Planning Board Report #20-06

**“CUSTOM HOUSE SQUARE”  
300 FORE STREET  
MAJOR SITE PLAN AND TRAFFIC MOVEMENT PERMIT REVIEW  
OLYMPIA EQUITY INVESTORS IV-B, LLC, APPLICANT**

Submitted by:  
Bill Needelman, Senior Planner

Date:  
March 24, 2006

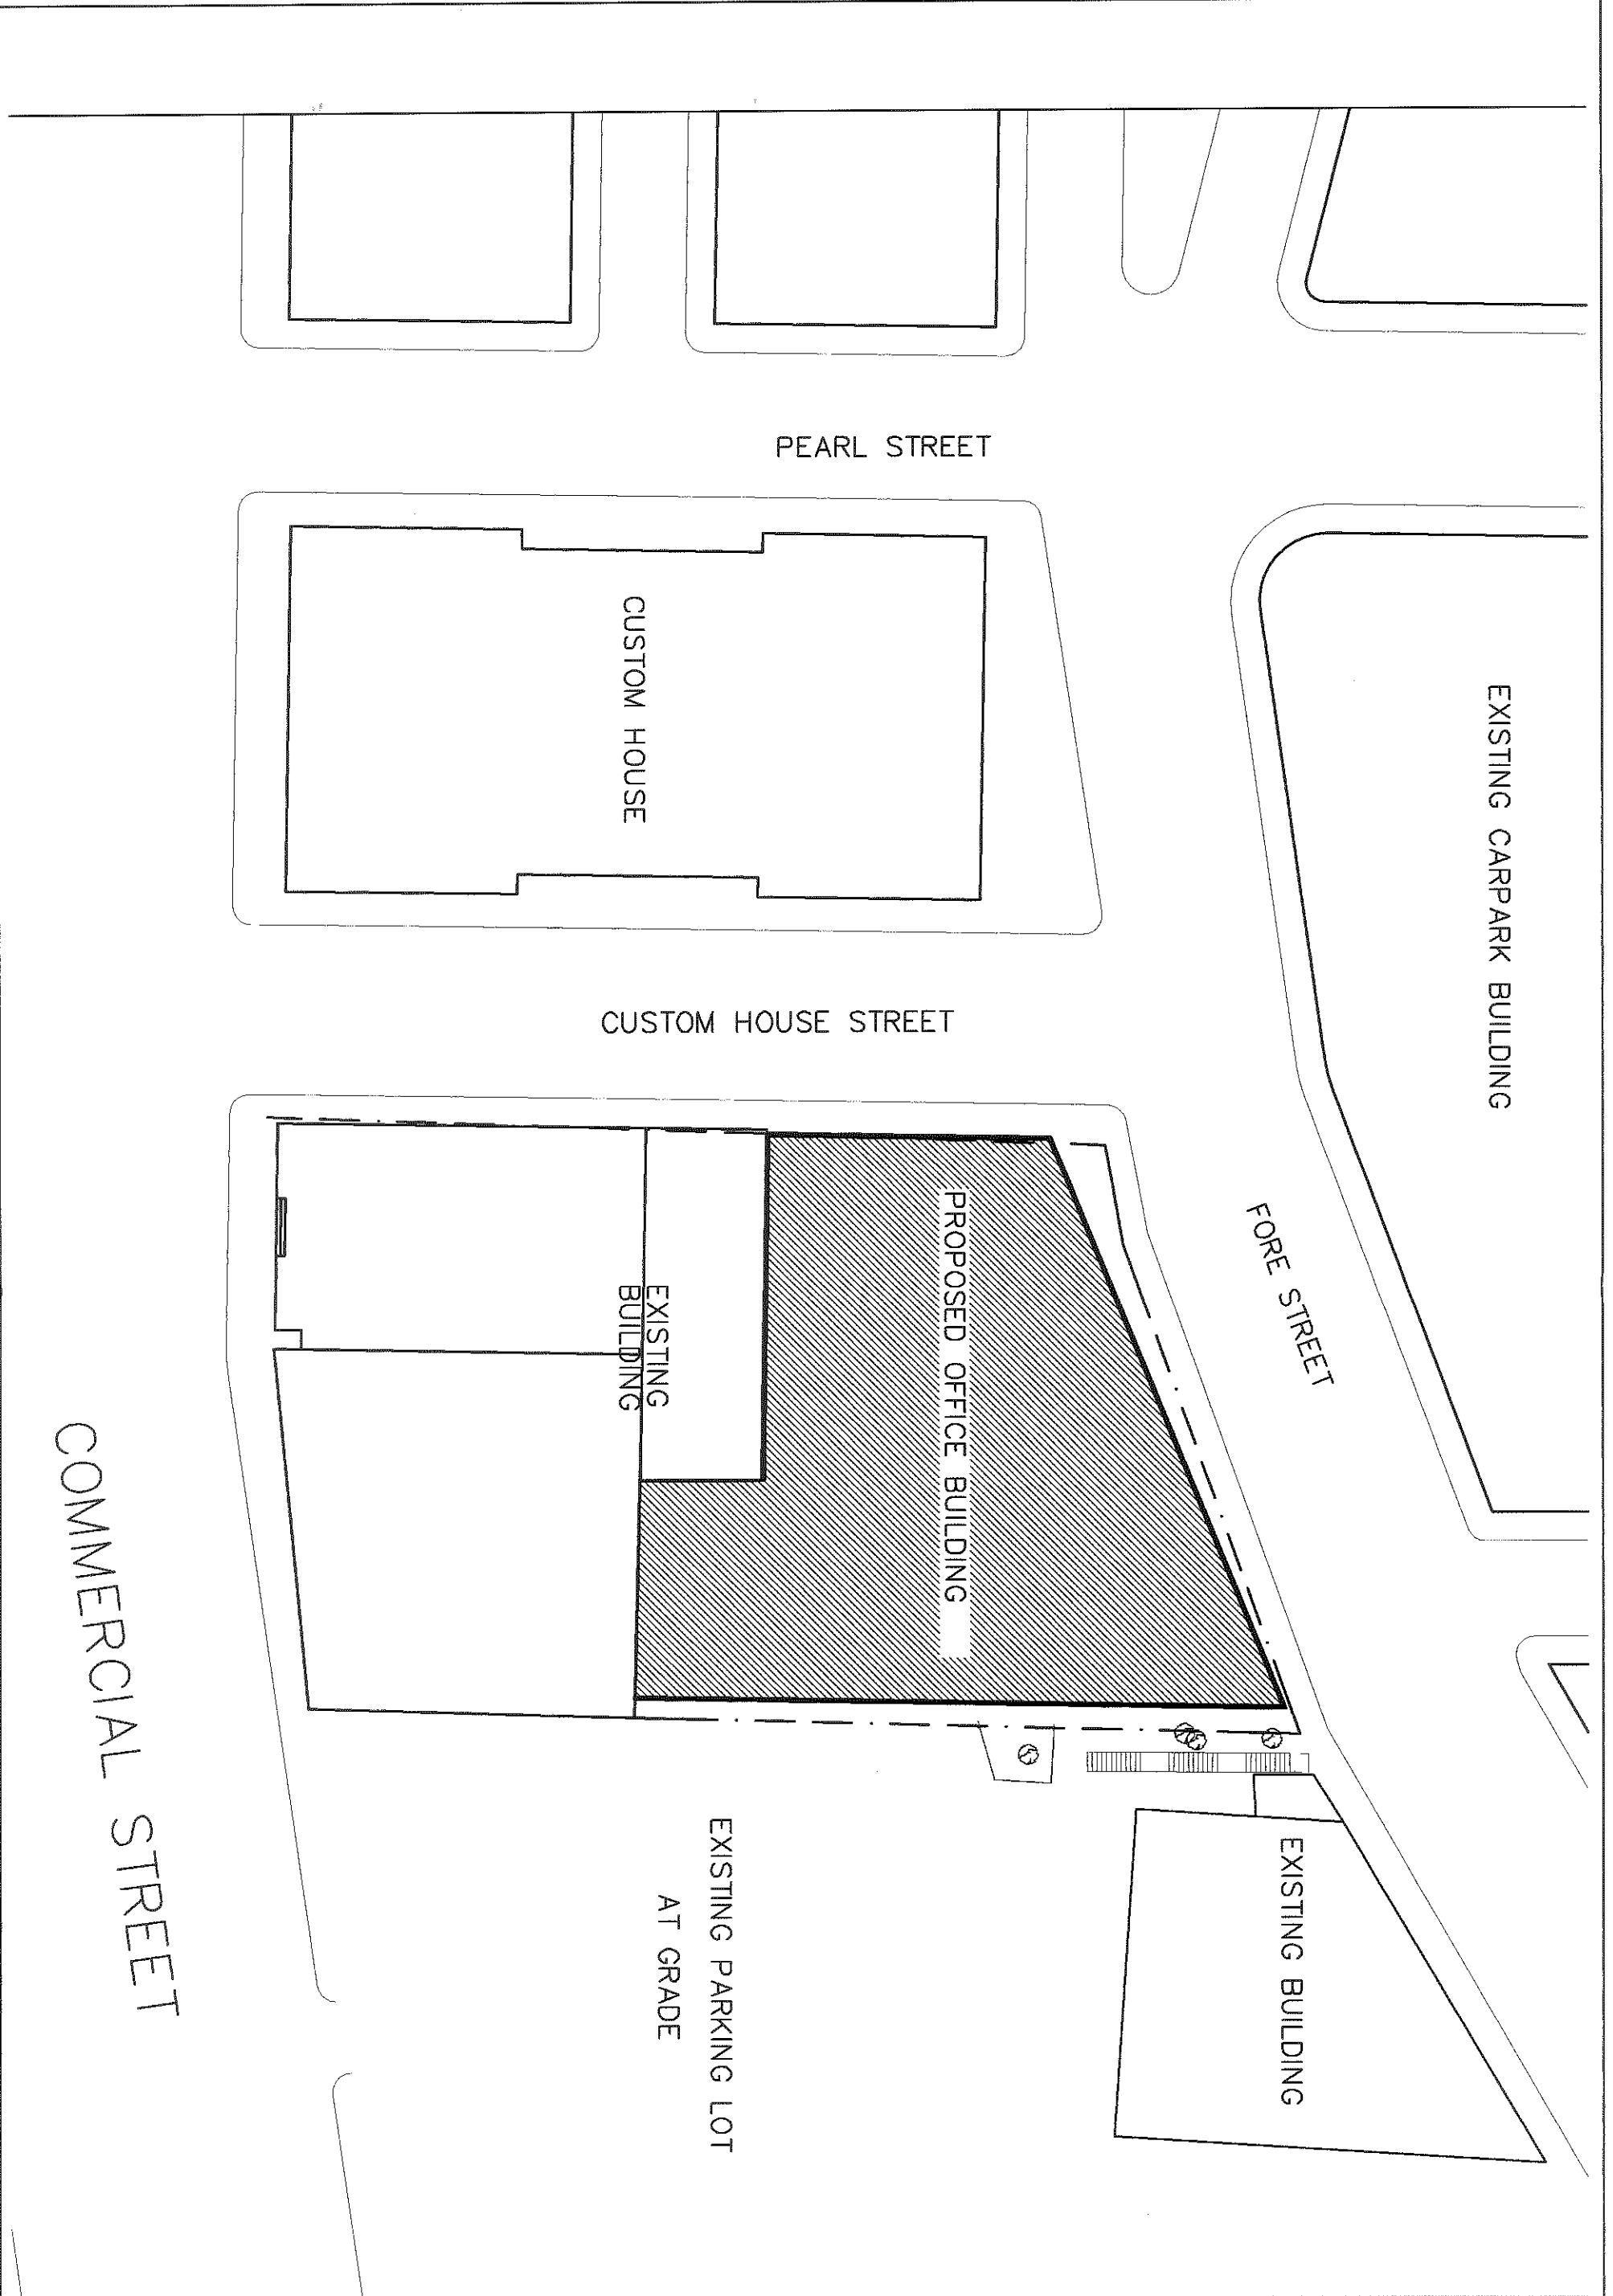
Dan Goyette, reviewing engineer with Woodard and Curran, and Eric Labelle, City Engineer, suggest that the curb geometry at Fore and Custom House Street be adjusted to better align with the curb at the Fore Street frontage of the Custom House. The applicants have provided a sketch of a possible alignment (attachment 24,), but this sketch has not been available for a thorough review. A condition of approval is suggested in the motions.

*I did review the concept plan (emailed to me today) of the enhanced sidewalk/corner area at the Fore Street/Custom House Street intersection and I generally find it to be acceptable. I would suggest that the curb extension extend farther along Fore Street to better shadow the parking spaces (the plan illustrates a 20-foot separation), but recognize that Eric needs to participate in this discussion.*
